ENG-SF19004-R4-FDR-Redlines. Summary_Markup Summary

ENG-SF19004-R4-SC-CDs-Redlines Summary_Markup Summary

HOMESTEAD AT STERLING RANCH FIL. NO. 2			
SAND FILTER PONDS LOTS 13-24			
PROJECT NO. 09-007	FILE: Yang\Const.Dwg\Street & Storm Plans\ST11.dwg	DATE: 11/19/2019	SHEET 11 OF 14 ST11
DESIGNED BY: CMM	SCALE: 1"=10'	VERT: N/A	
DRAWN BY: CMM	CHECKED BY: VAS

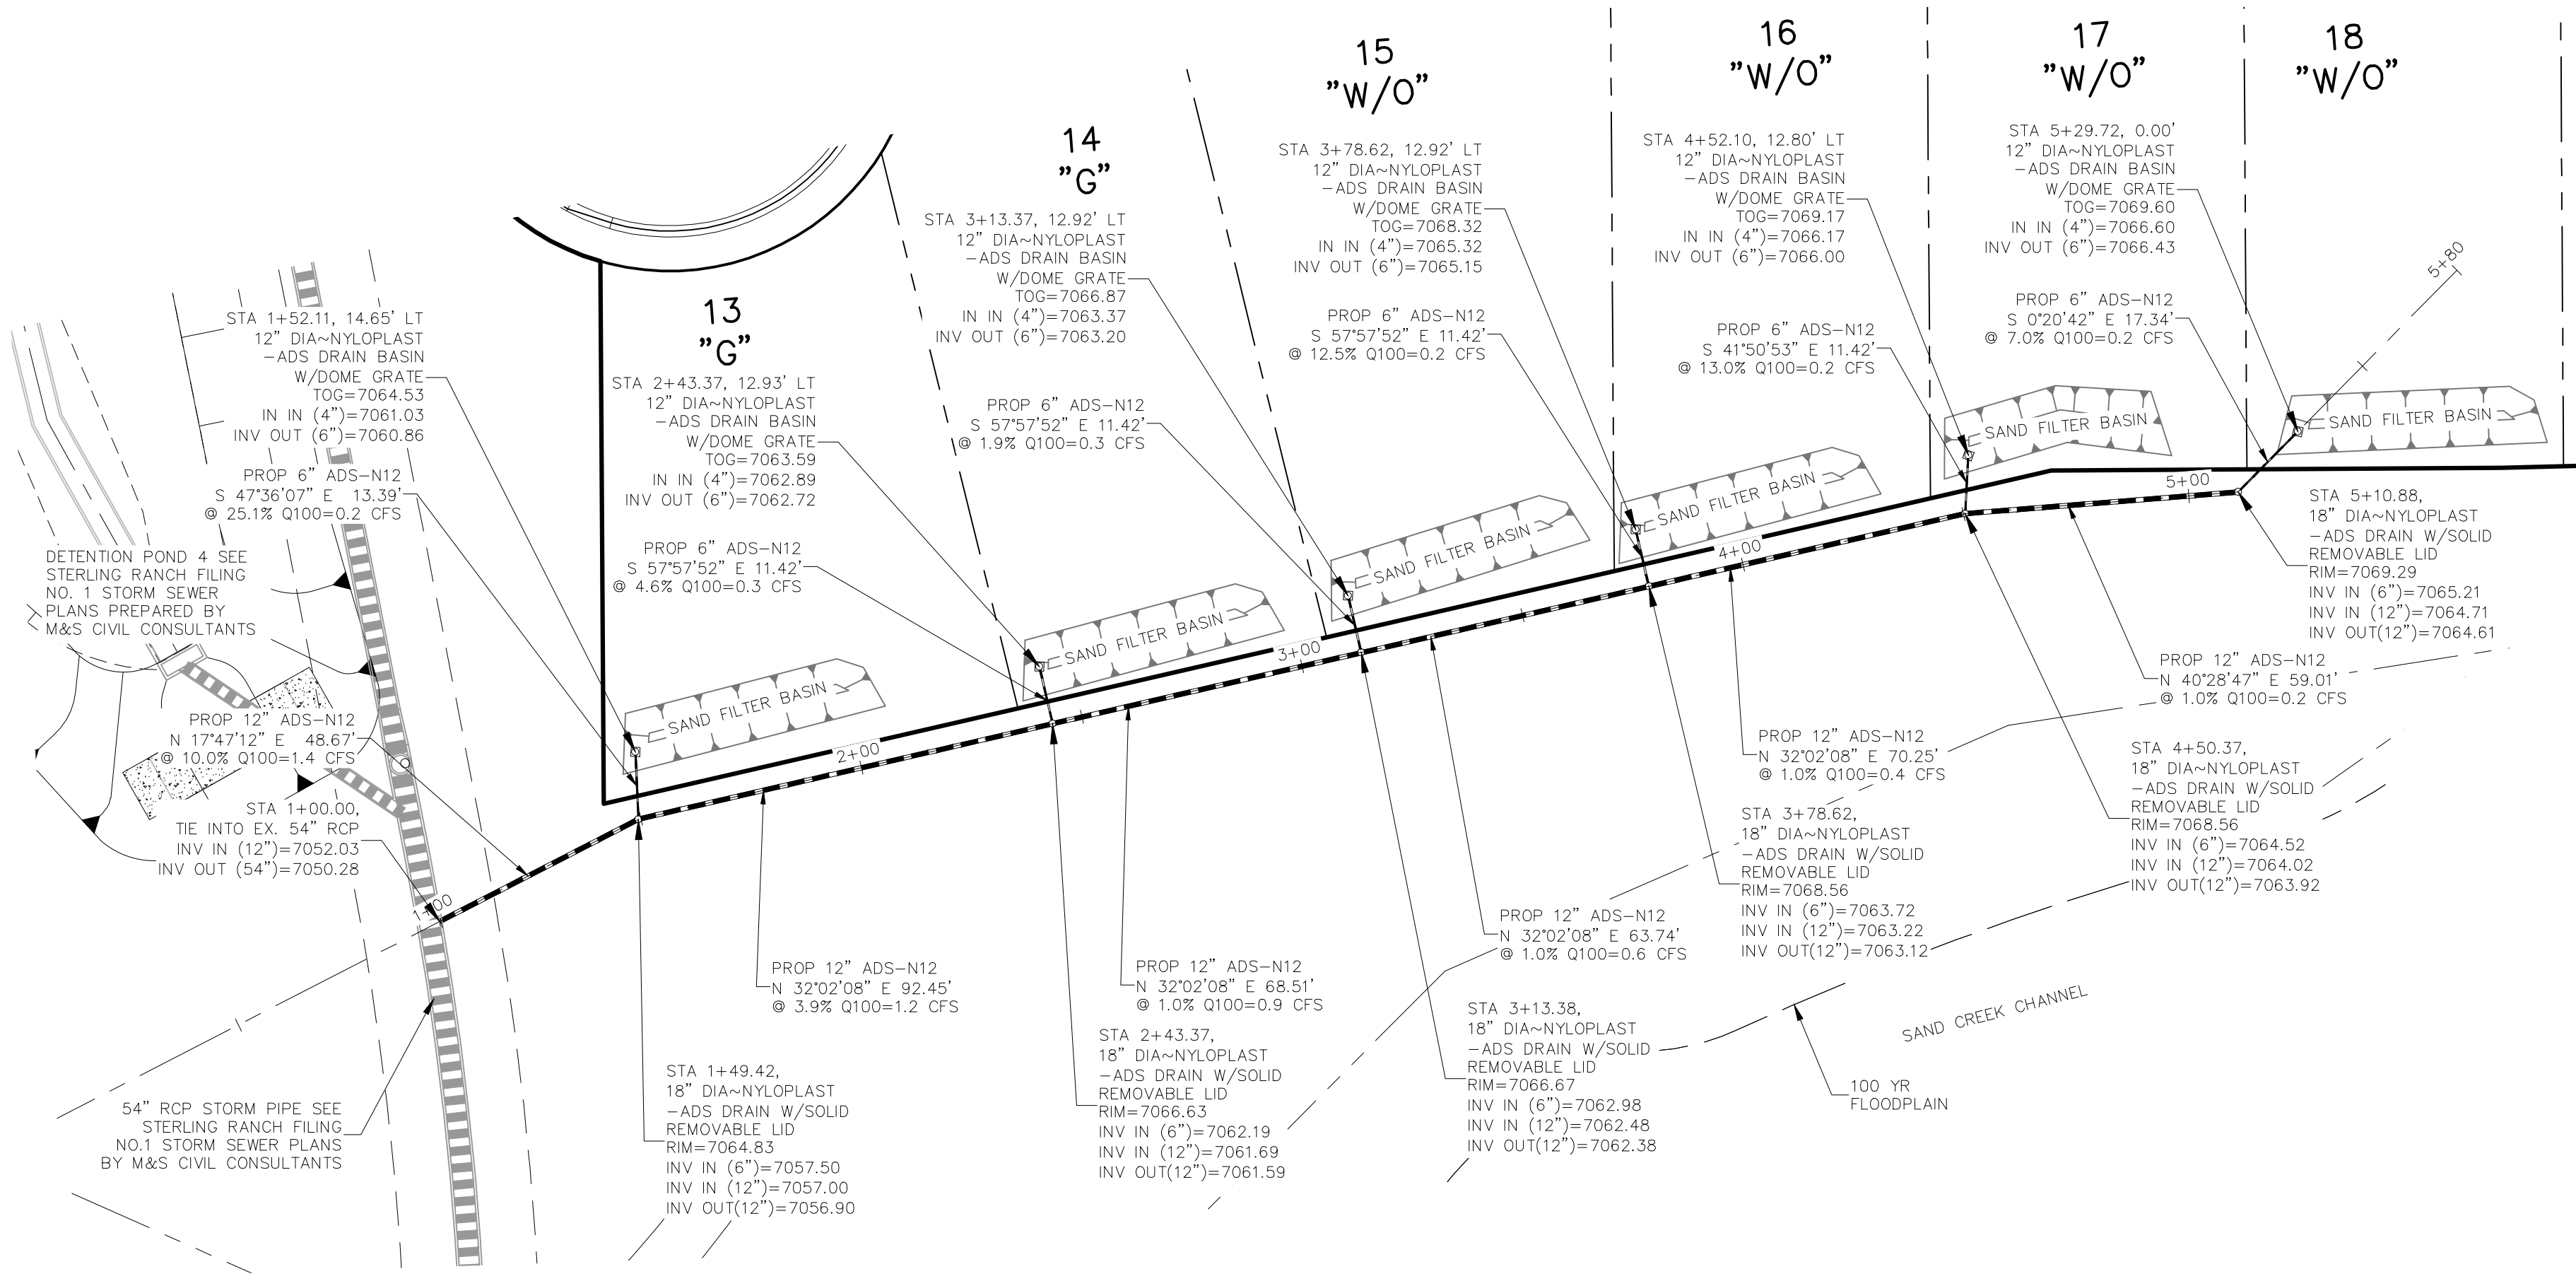
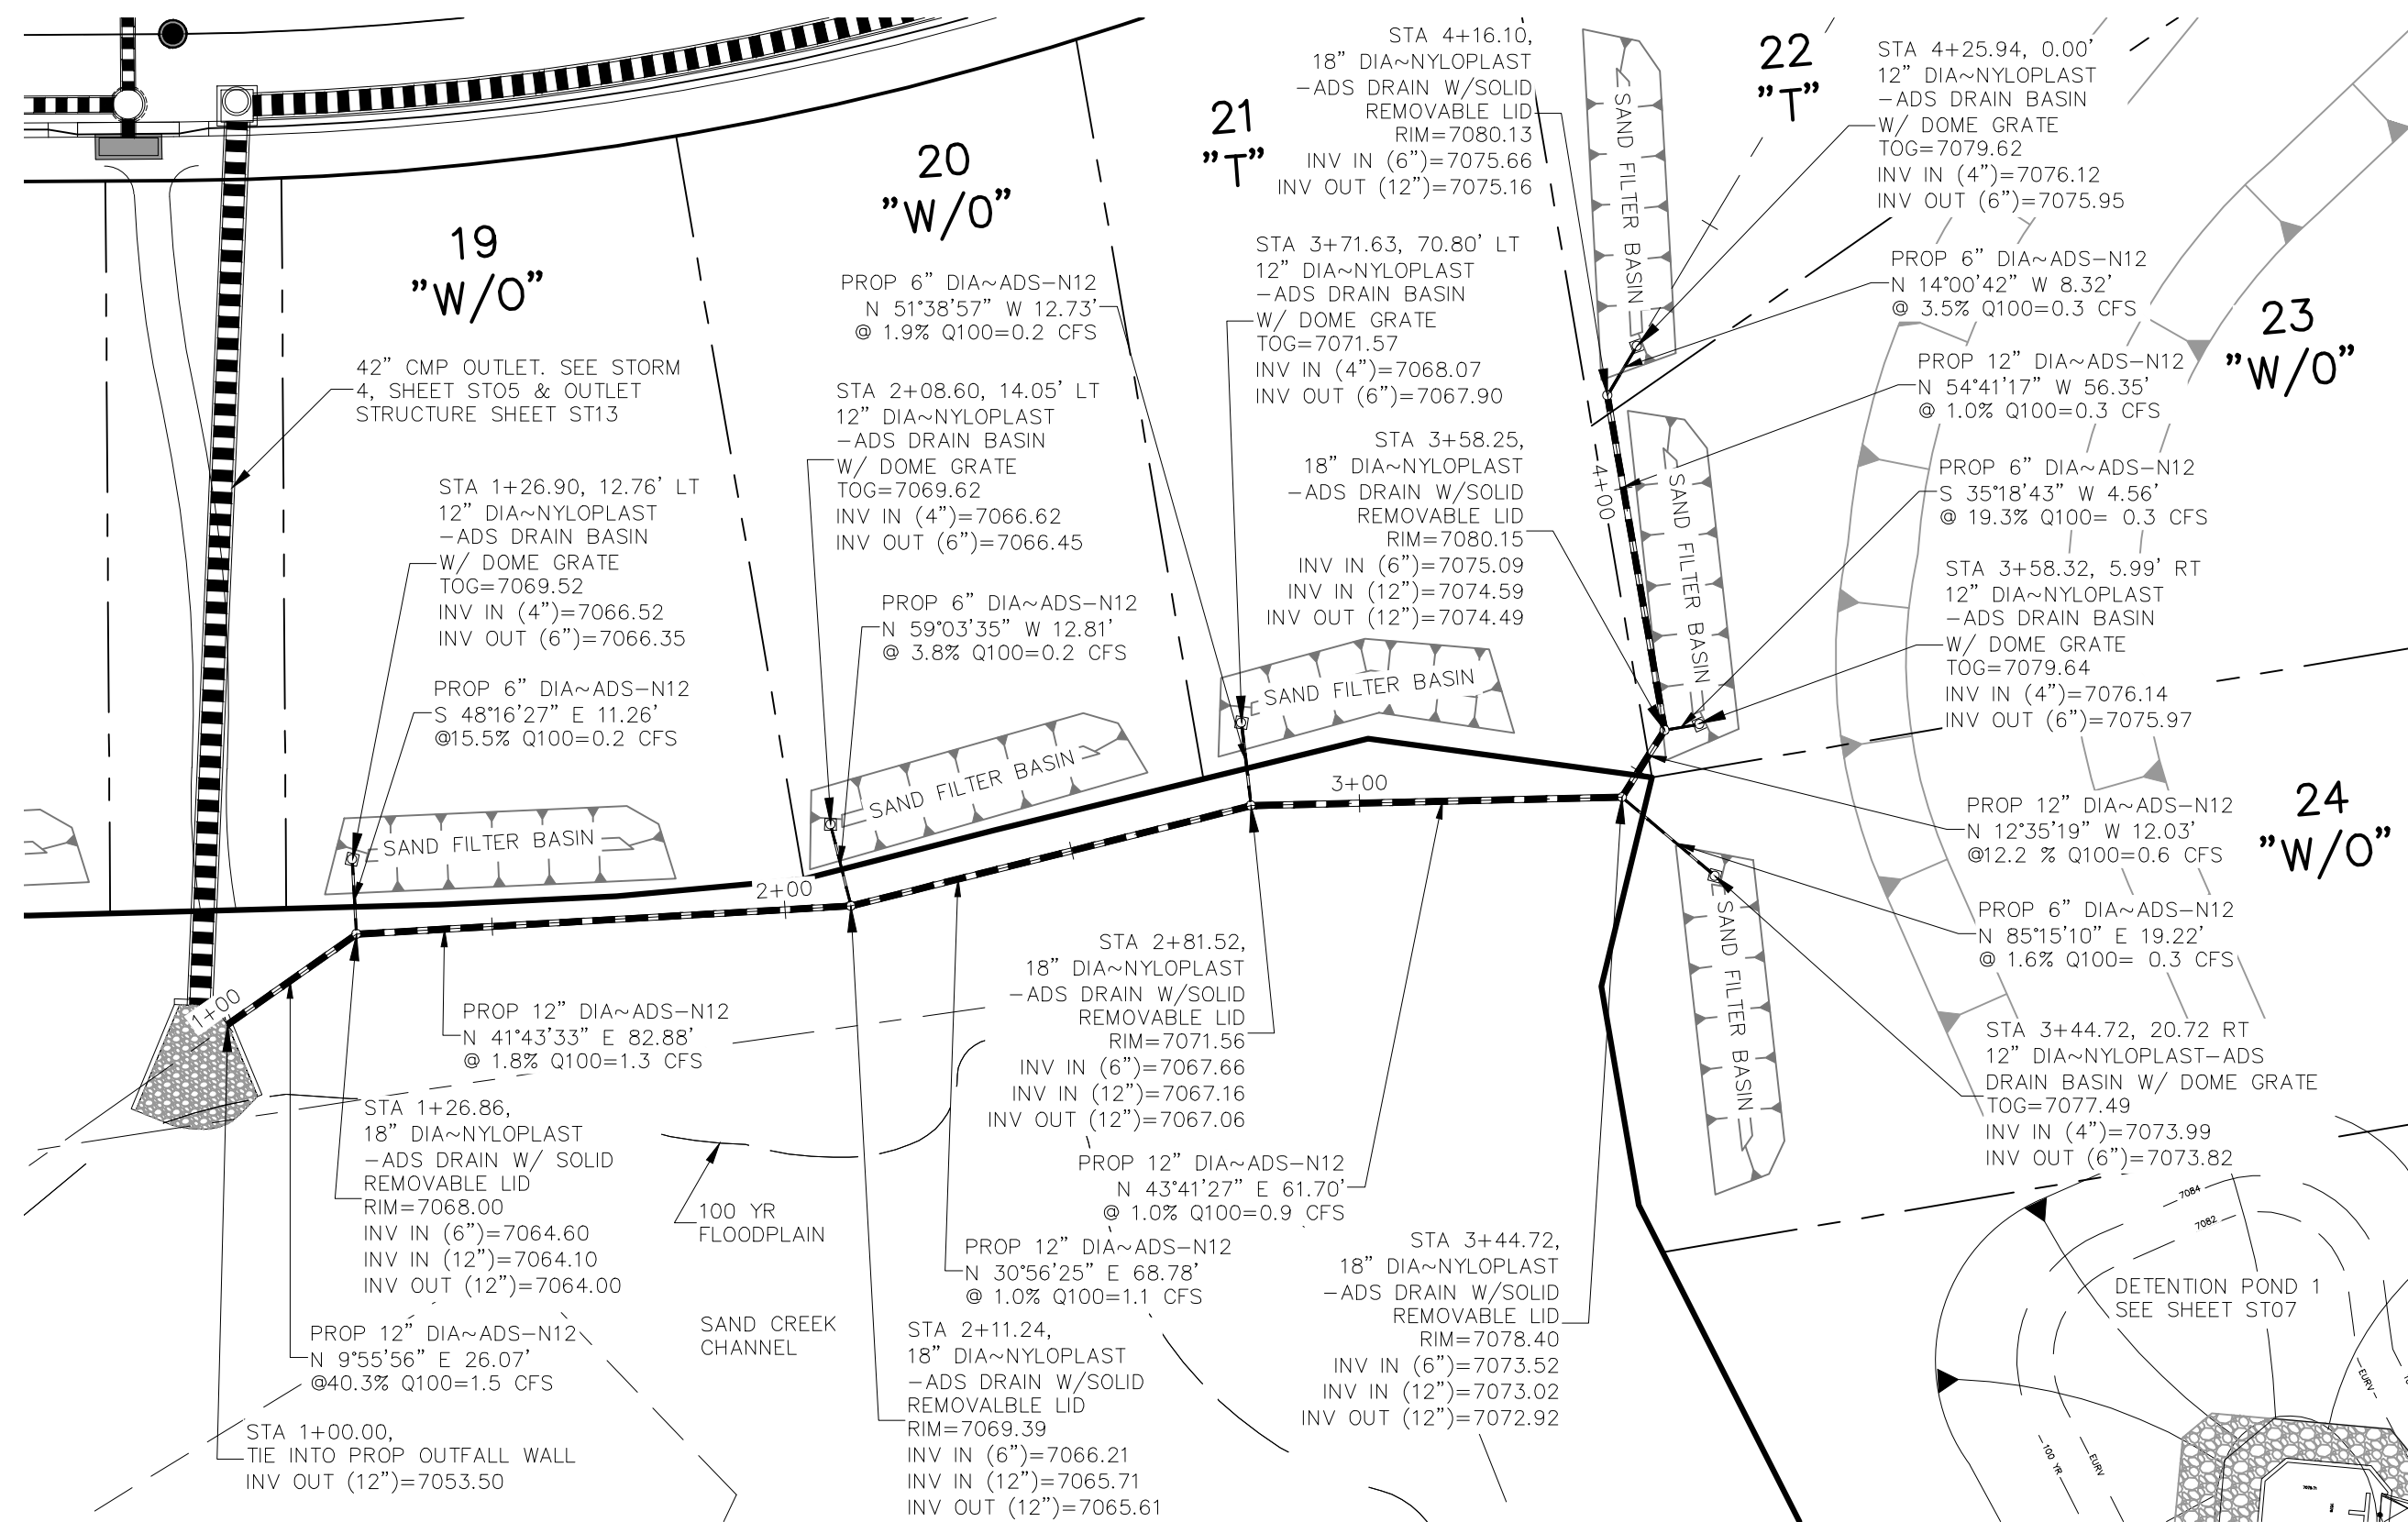
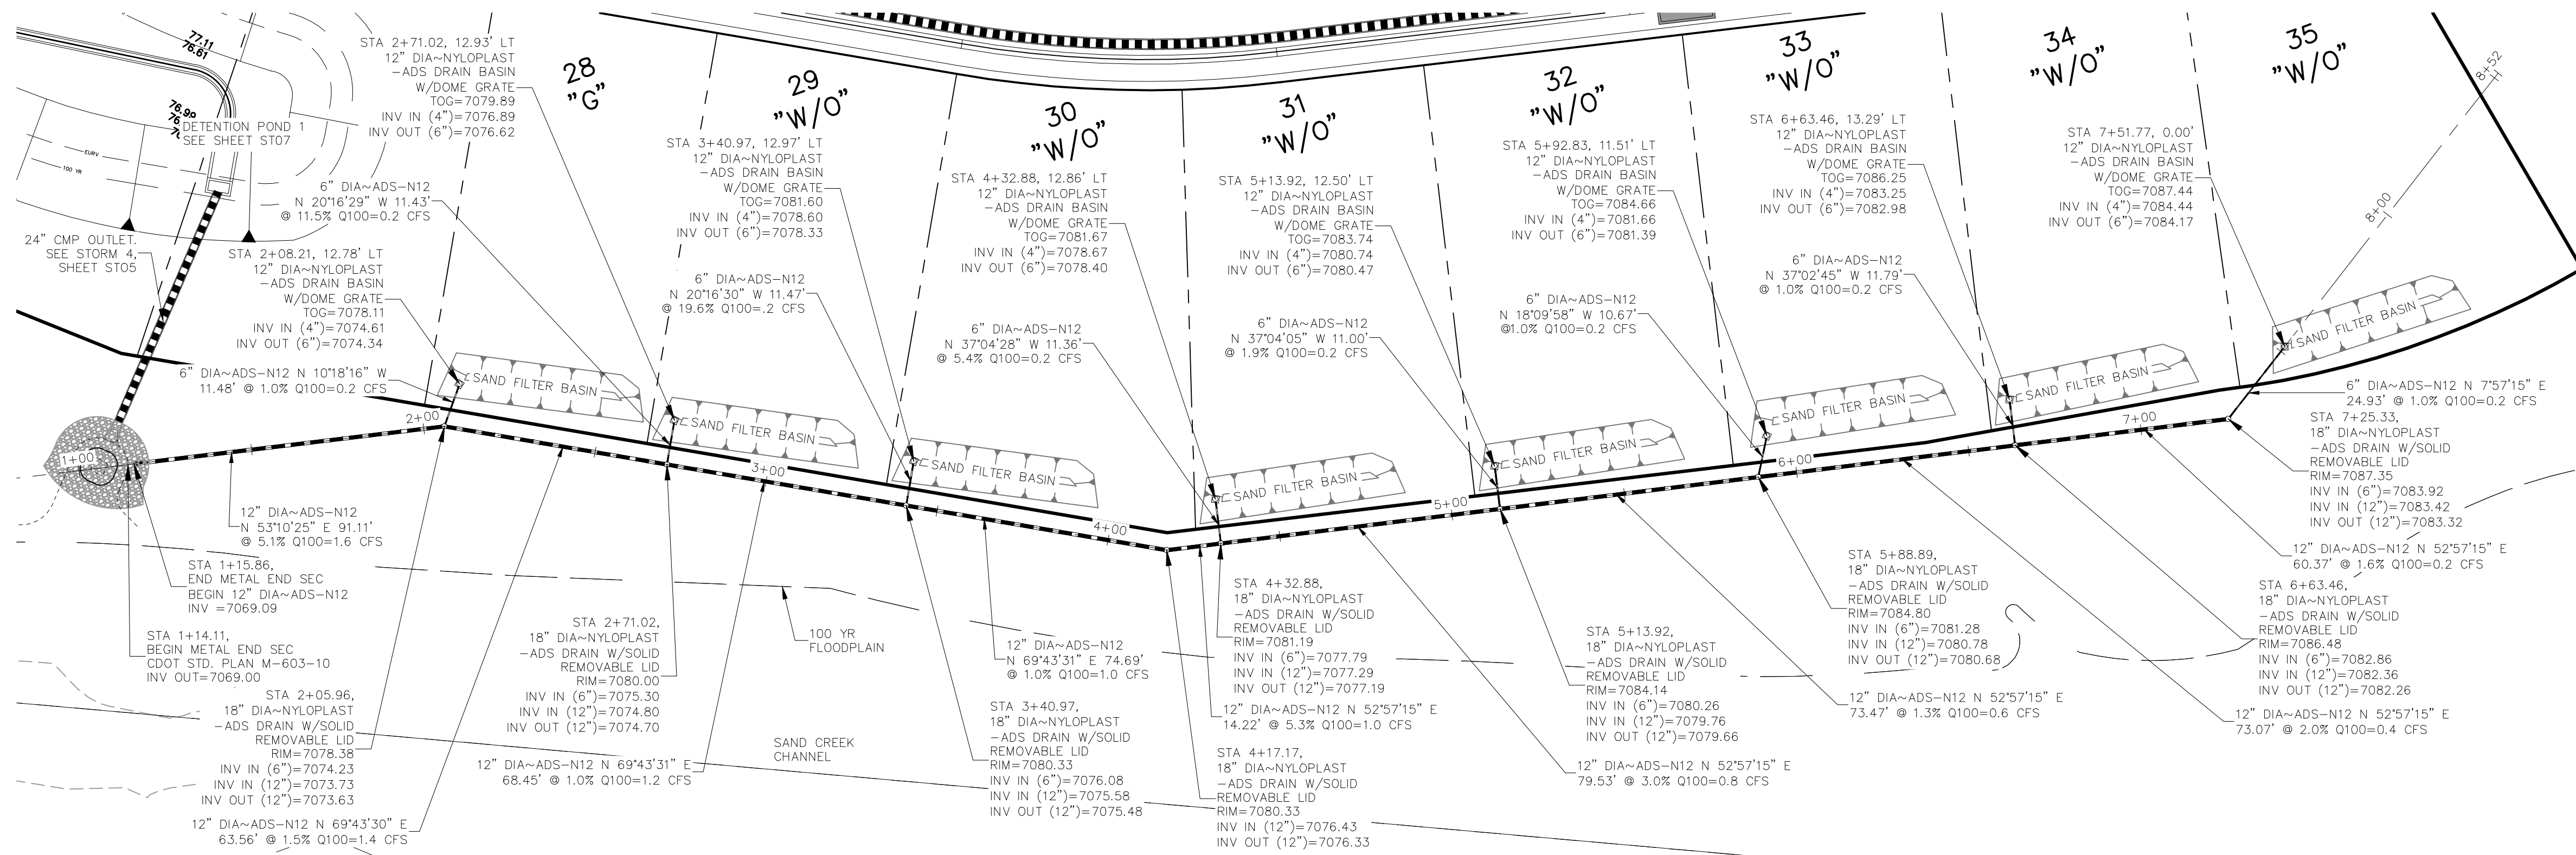
Add a more specific detail for the 52 SFB's that will be used for back yard WQCV. Since all 52 will be similar, provide the outlet structure detail, the outfall pipe sizing information, Fencing, (Split rail fence), etc.
